From: Richard Hart [REDACTED]
Sent: 03 December 2020 21:33
To: Planning <Planning@arun.gov.uk>
Subject: Fwd: Objection to Planning Application - AB/114/20/PD

Objection to Planning Application

AB/114/20/PD
Riverside House

2 Fitzalan Road
Arundel
BN18 9JS

PROPOSED ROOF PLAN

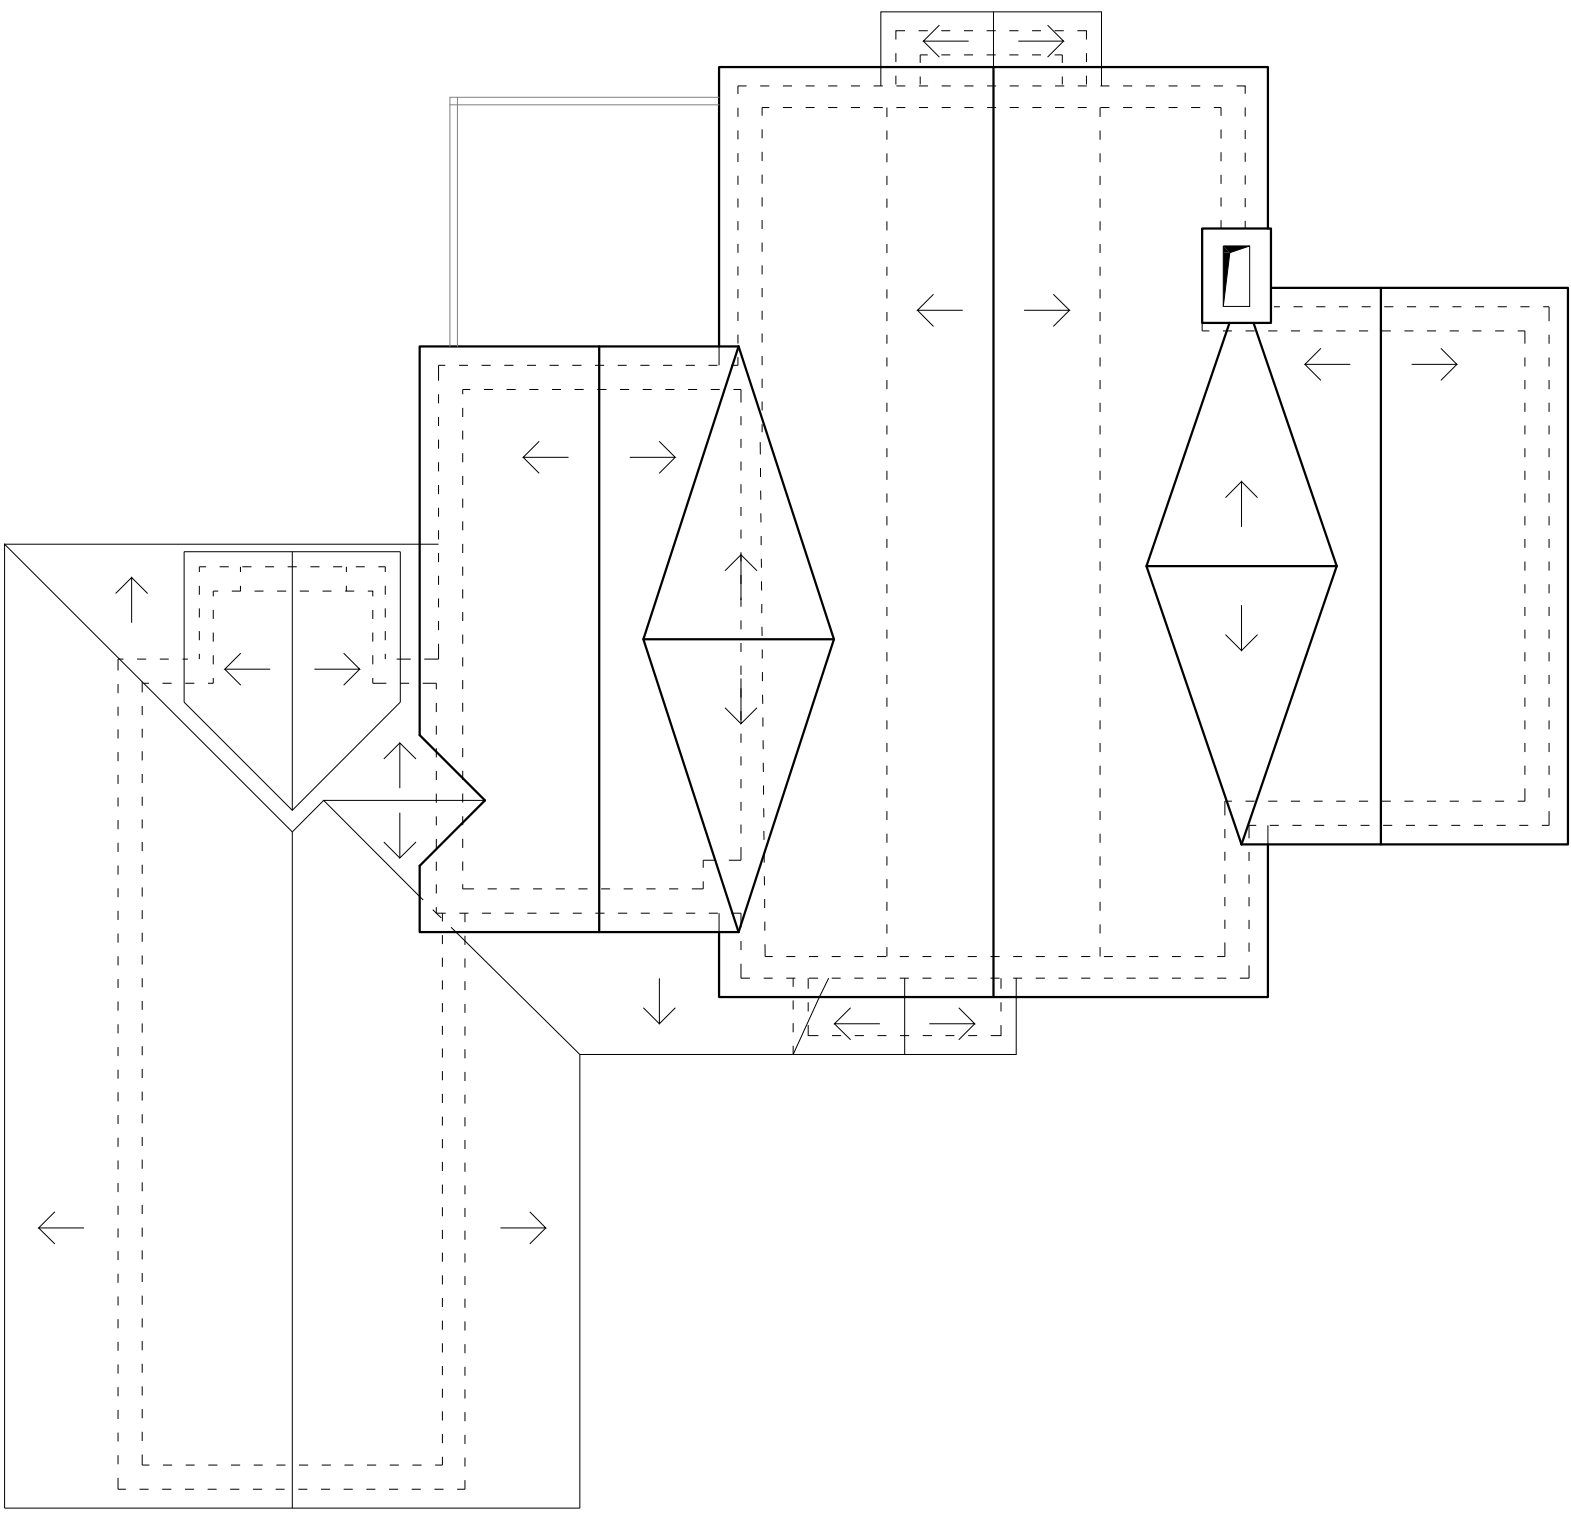
3. The proposed elevation will obscure the view into and out of the Arundel Conservation Area, much to its detriment.
4. I note from the plans that there are some eleven proposed bathrooms, the future intent for which is surely a multi-occupancy dwelling of several flats. If this is indeed the case it should be declared as such, and not become an example of incremental development by stealth. If the intent is for a multi-occupancy building then parking requirements should be appropriately scaled, and the increase in traffic taken into consideration at this stage of the planning application.
